Your reference: SSD 6674
Our reference: EF13/5547, DOC15/71040-02
Contact: J Goodwin 9995 6838

SSD 6674 – UNSW BIOLOGICAL SCIENCES PROJECT EIS

ATTACHMENT A
- ENVIRONMENT PROTECTION AUTHORITY COMMENTS -
UNSW BIOLOGICAL SCIENCES PROJECT

Original Noise Logging Data (November 2014)

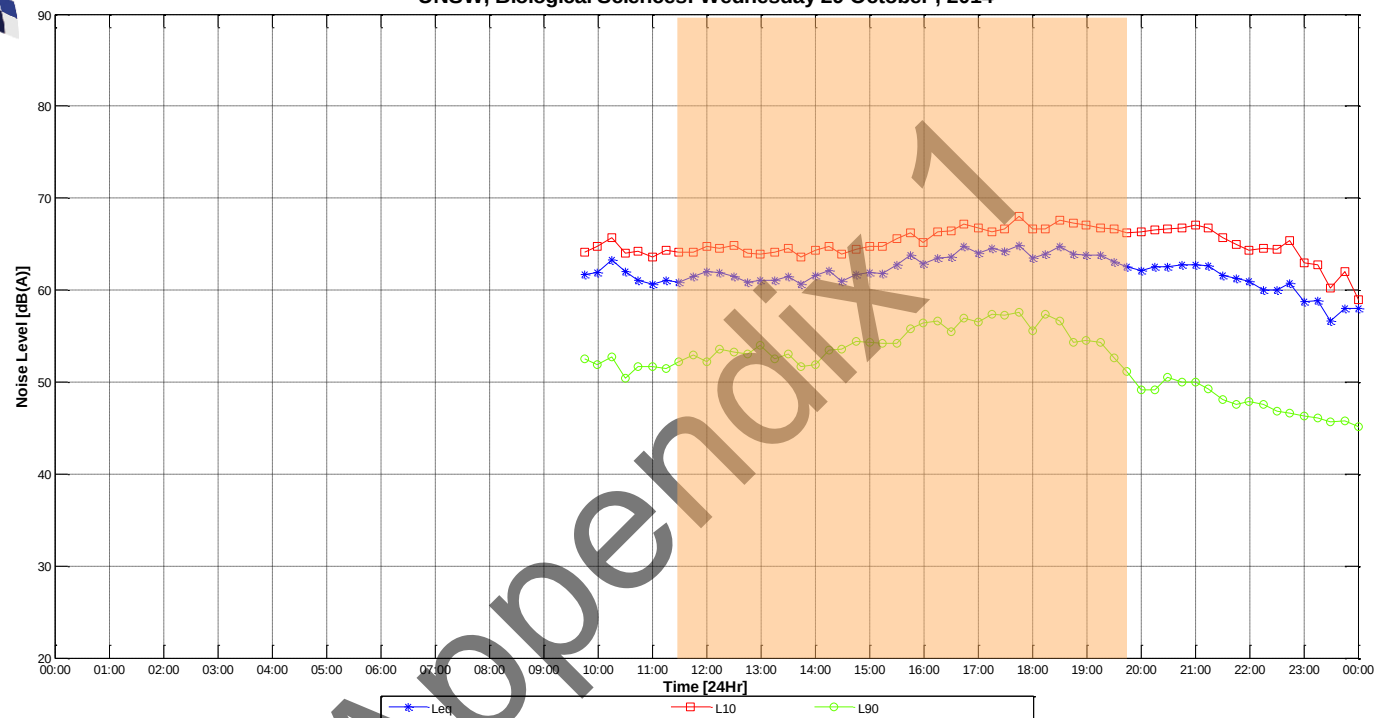
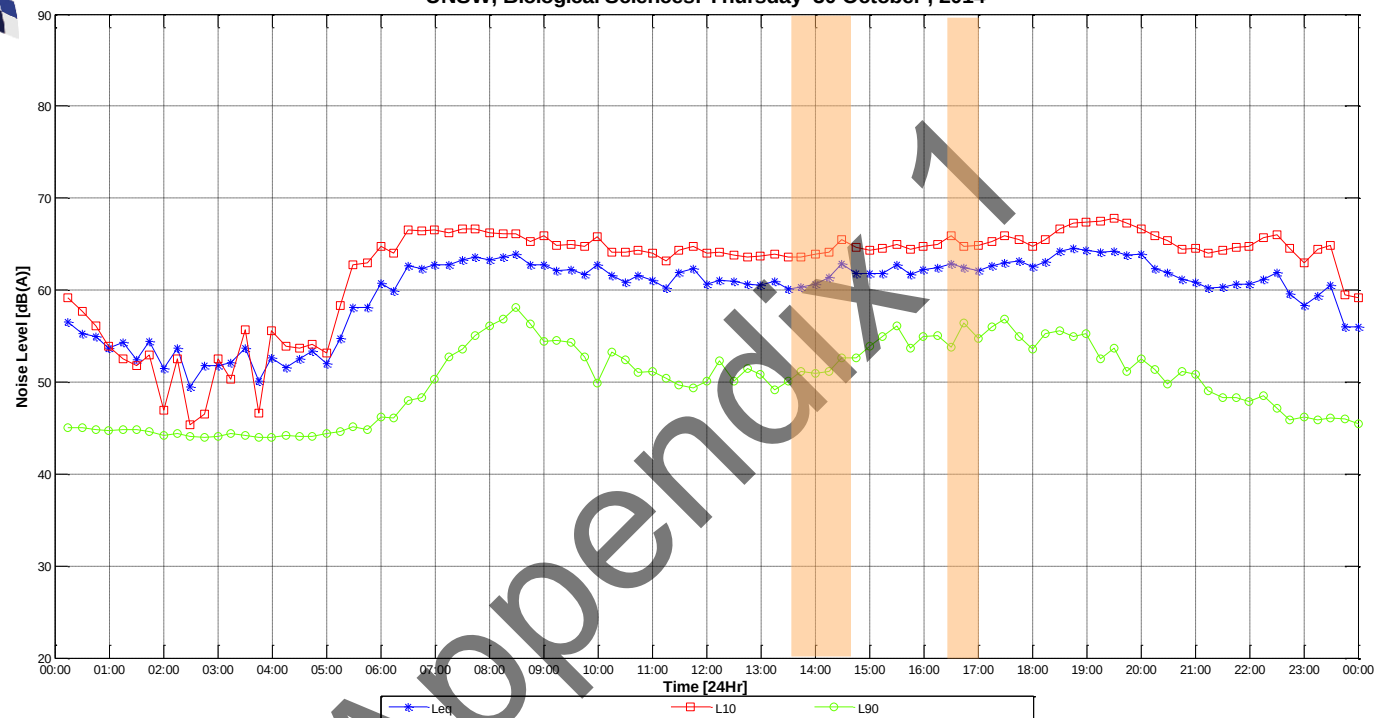
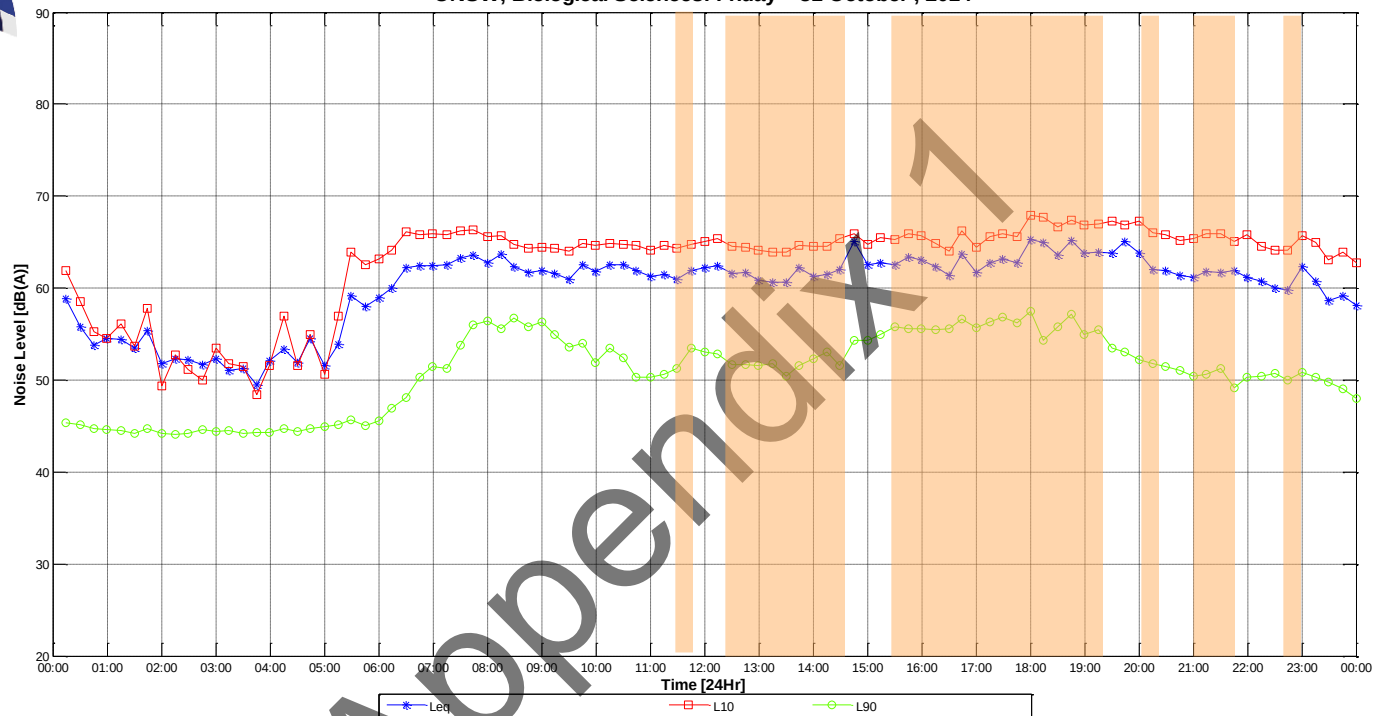
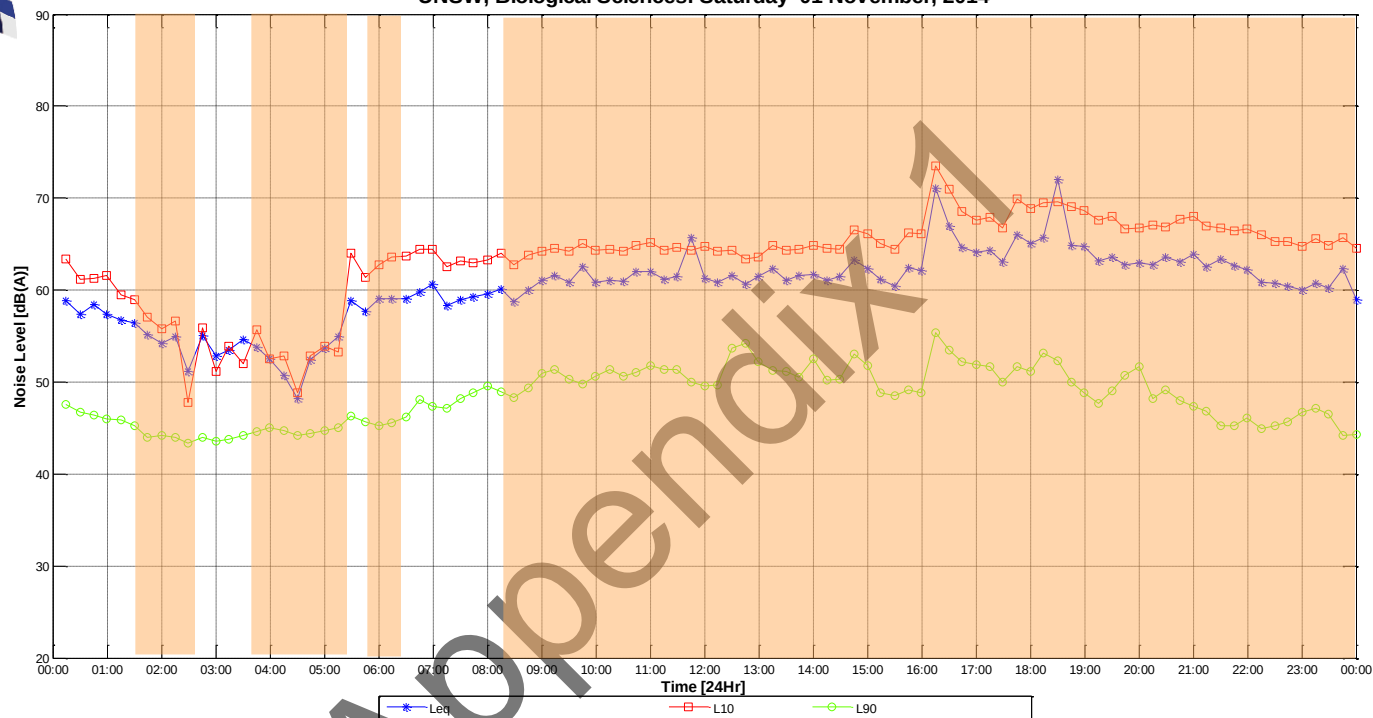
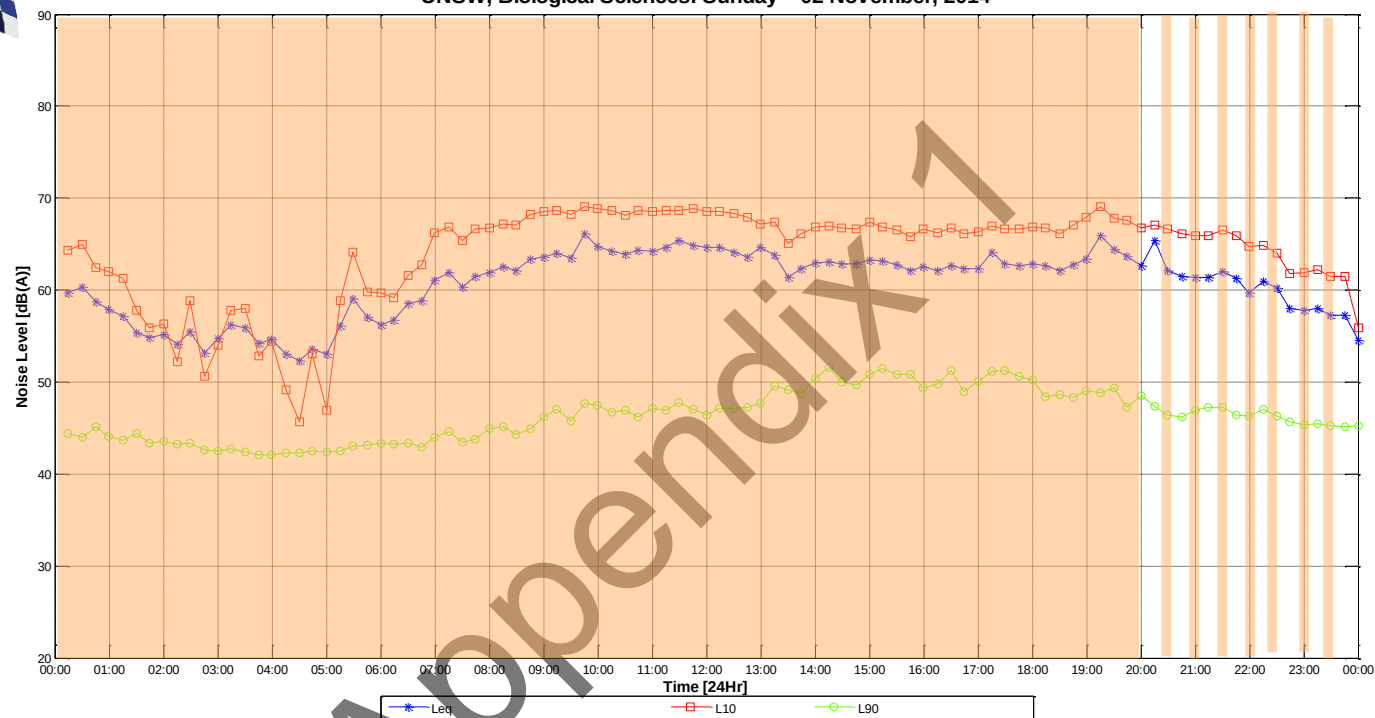
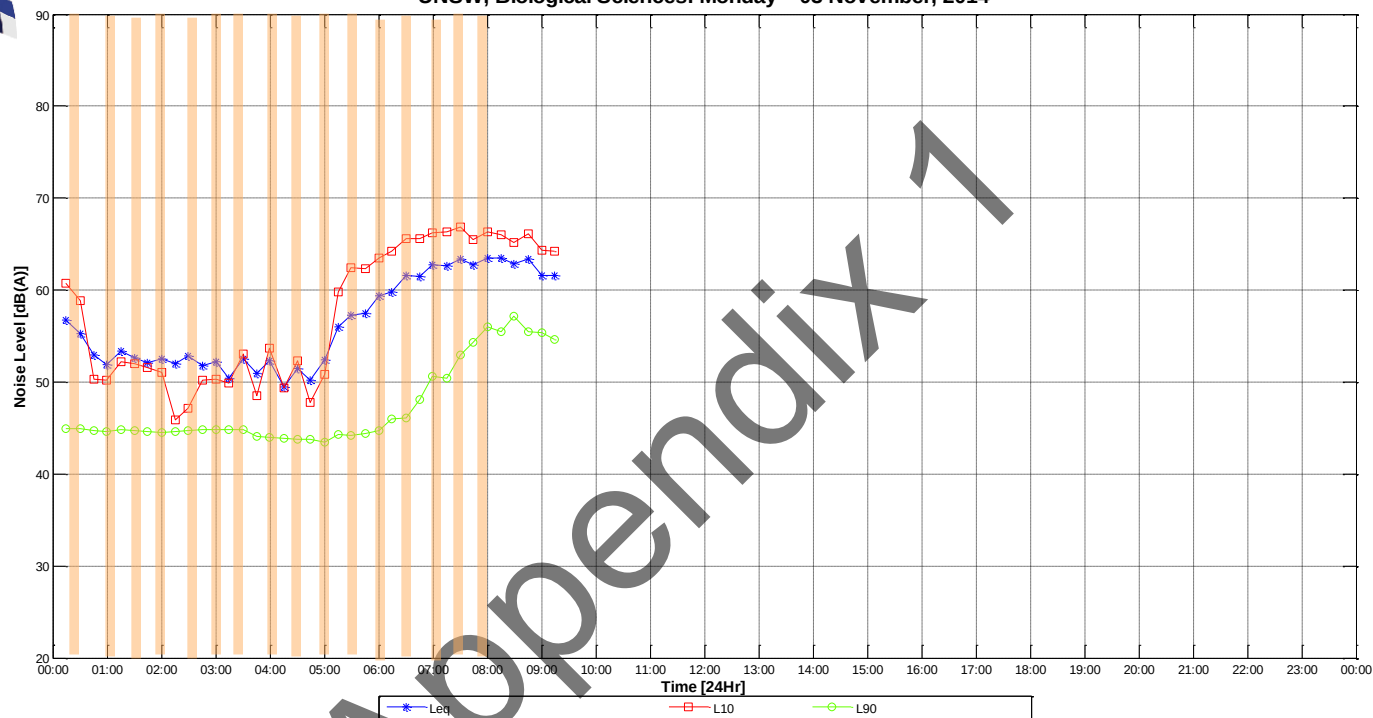
However, EIS Appendix G indicates that noise monitoring to establish background noise levels, which are fundamental to assessing operational noise impacts, are questionable because the measurements:

- (a) were limited to only 5 days of background monitoring rather than the minimum of 7 days required by the guidance material in the NSW Industrial Noise Policy (INP);
- (b) are not supported by any assurance that they measurements were not affected by adverse meteorology (i.e. rain or winds with a velocity exceeding 5 metres per second);
- (c) were not made at or near the boundary of noise sensitive receivers (example: most affected residences particularly to the east but including the most affected nearby residences to the north and south);
- (d) were not made at nearby hospitals located to the east along Hospital Road; and
- (c) were made at a location adjacent to a university building, which may have raised night-time background levels due to the influence of -

- (i) mechanical plant, and
- (ii) façade reflection.

The proponent be required to undertake background monitoring at the most affected residential receivers and both hospitals in accordance with the guidance material provided in the NSW Industrial Noise Policy.
